Our ref: HMS ID 14435

Advice on Response to Submissions – State Significant Development

Proposal: Mixed use development with infill affordable housing - Oxford and Verona Street, Paddington

Major Project reference: SSD-87245208

Figure 3 Overlay of proposed ground floor impacts to areas of archaeological potential.

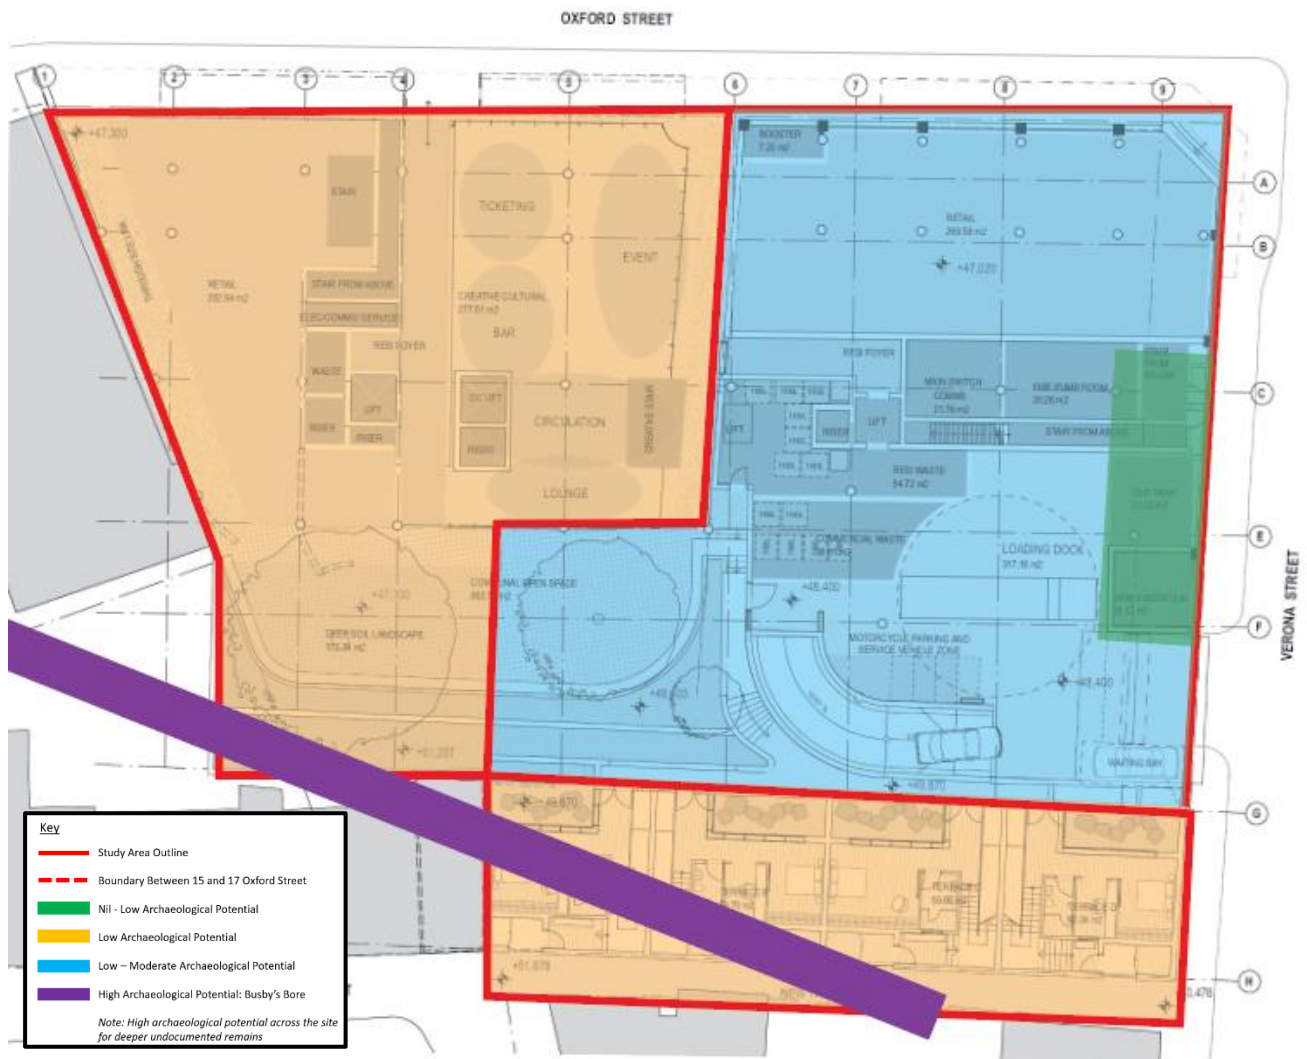
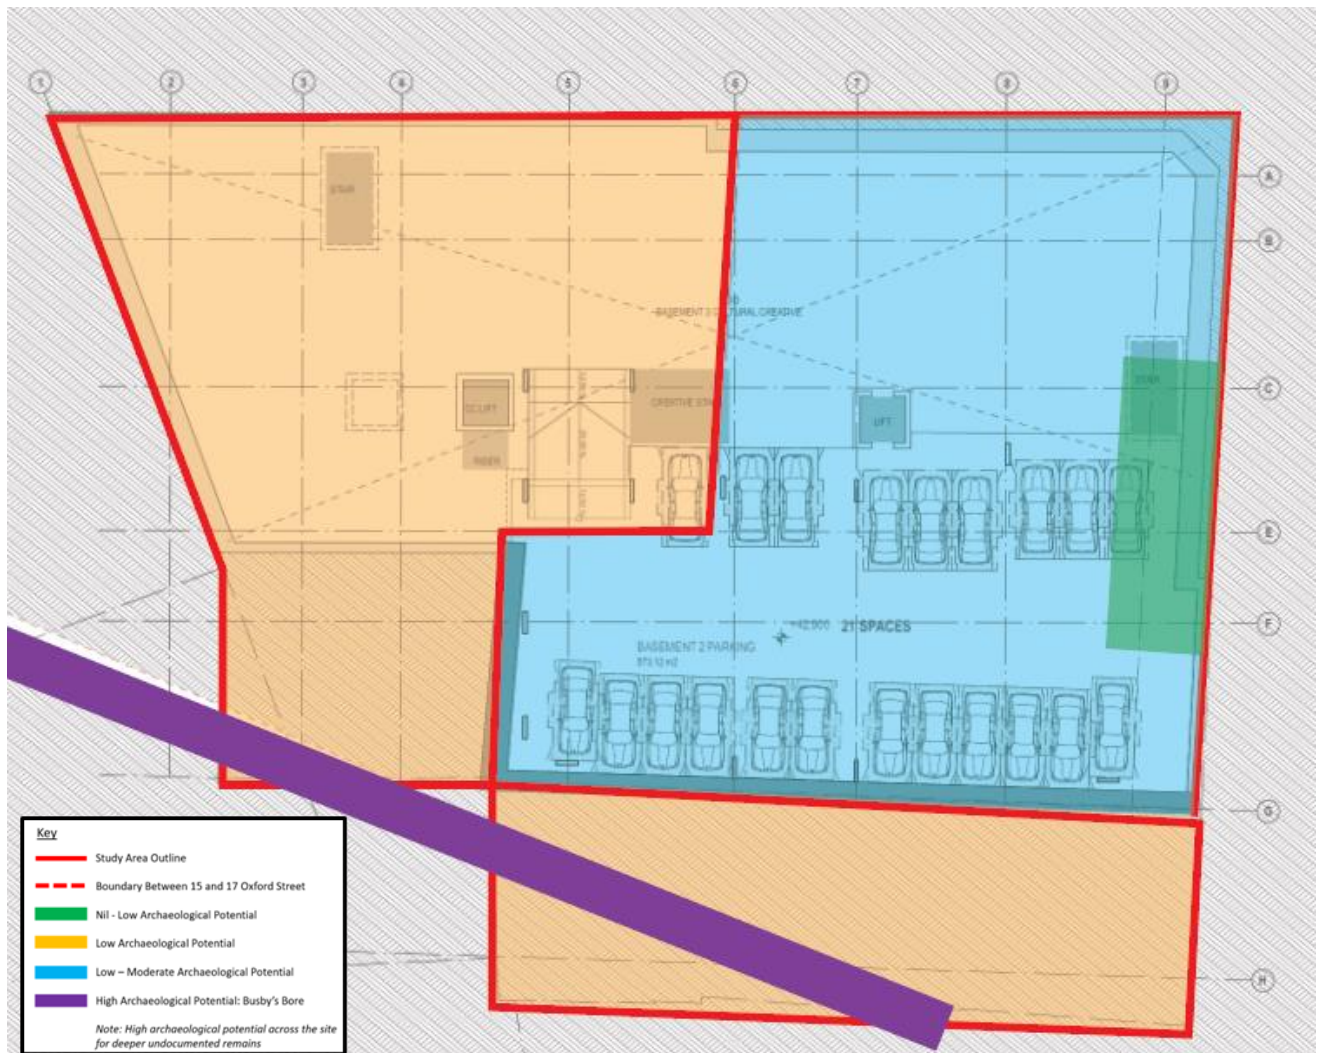
- The response provided by the applicant to item 1 discusses works proposed within the existing basement underlying 17 Oxford Street. The request for information relating to piling and excavation depths from Heritage NSW relates to the areas outside of existing basements at 2 Verona Street and the rear of 13-15 Oxford Street, which surround the mapped location of Busby's Bore. We recommend that the Department request the proponent to confirm if piling will be required in this area as well as the depth of excavation required to enable the proposal in this area. As noted in the previous response from Heritage NSW, there are conflicting statements in the EIS documentation relating to this matter.

Figure 5 Archaeological Zones.

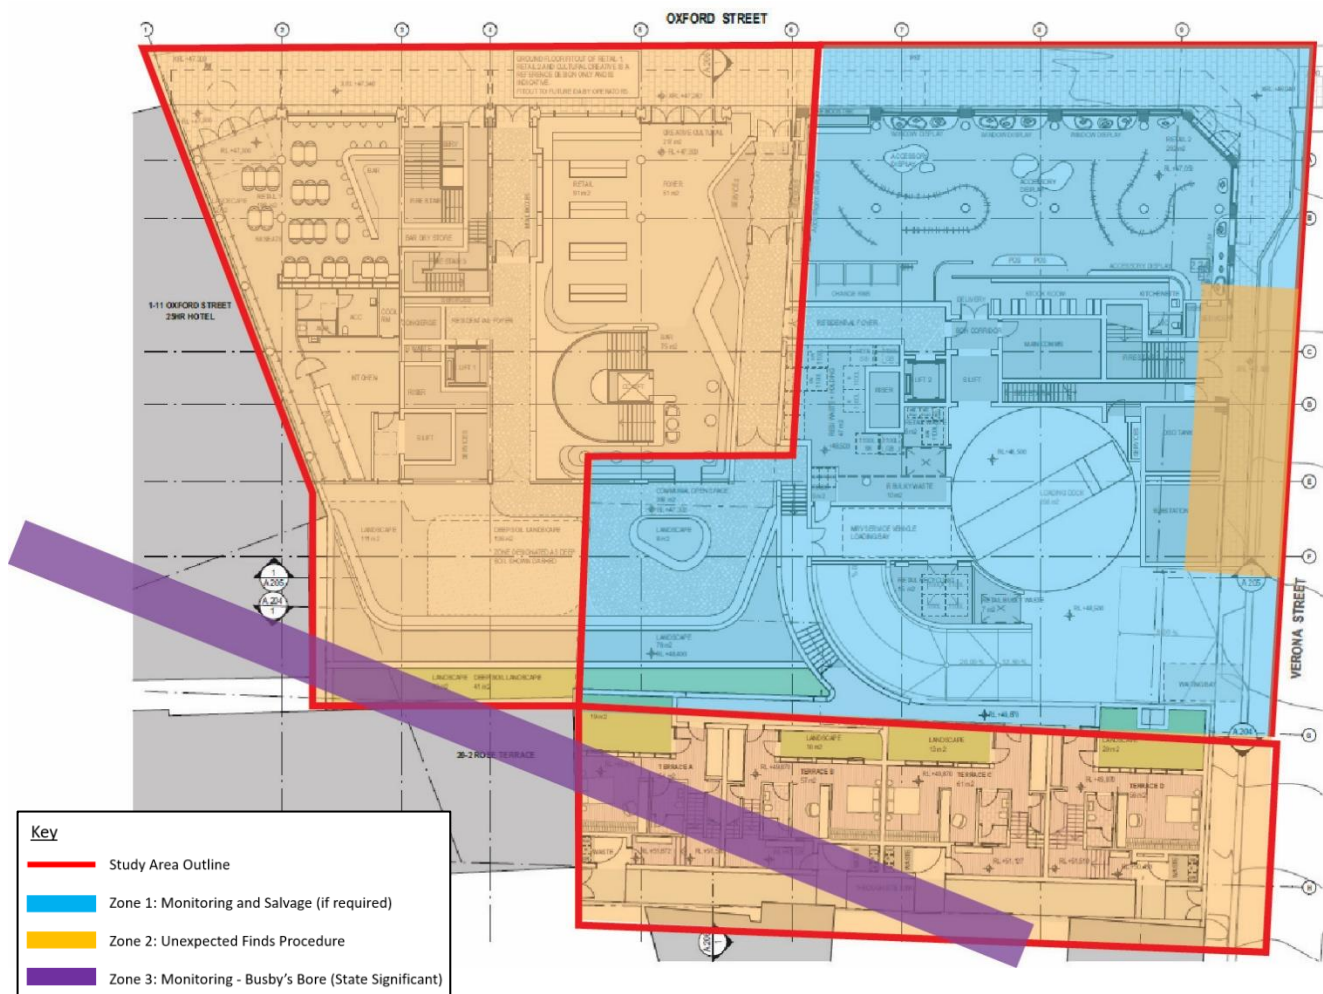
- We note that the geo-tech report identifies Busby's Bore as a sensitive item and recommends a comprehensive vibration control and management plan be prepared for the construction phase. We support this recommendation.
